MPC Ref: 160548

RE: Newcastle Jockey Club - Chatham Street Stables Complex (SSD-12982045)

MPC has prepared responses to the relevant items listed in the correspondence from the City of Newcastle ('CoN') reference SDC2021/0014 dated 10 June 2022.

TURNING PATH ENTRY PLAN SHEET 5

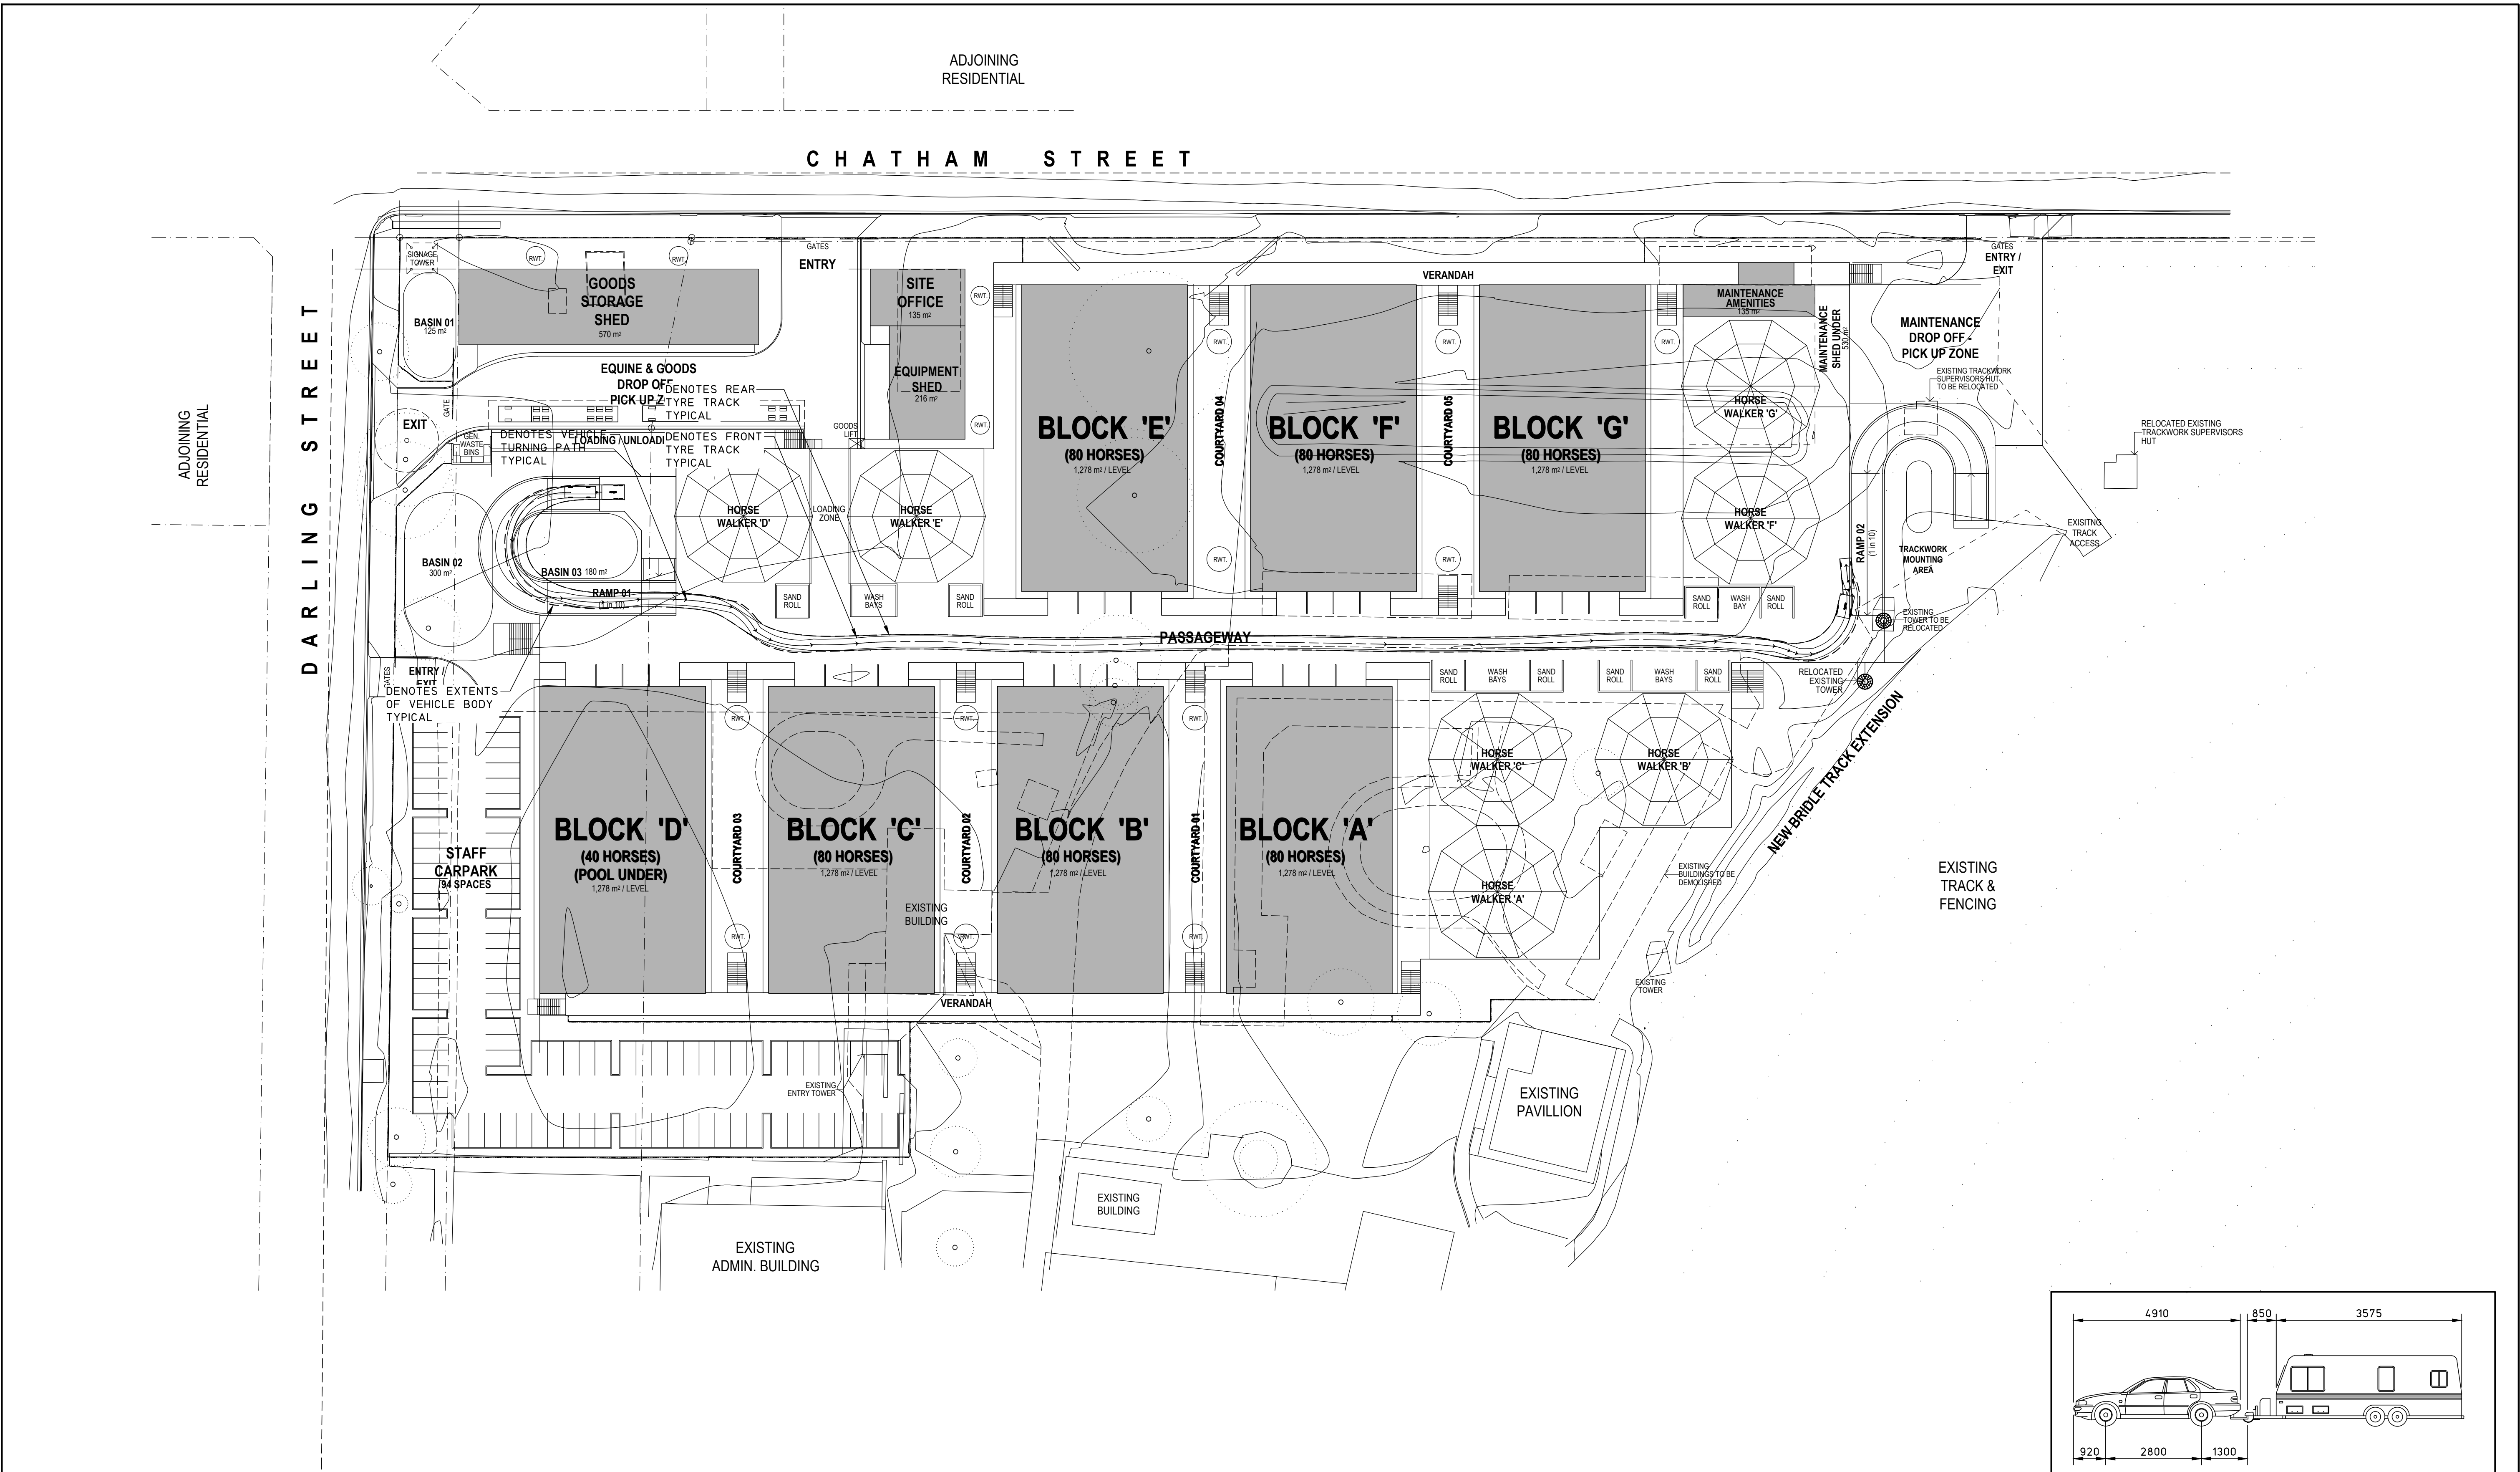
Turning Path Plan Sheet 5 (Dwg No. T05) indicates a B85+Horse Float exiting the site via Ramp 01. Turning Path Plan Sheet 4 (Dwg No. T04) shows the same ramp to be used as an entry. Safety concerns are raised at this interface and on the ramp. Turning movements at Horse Walker G2 are also in question.

As per the response to the previous comment, the very low risk of collisions can be safely managed by the above-mentioned traffic controls in the rare emergency event that access by the float was required.
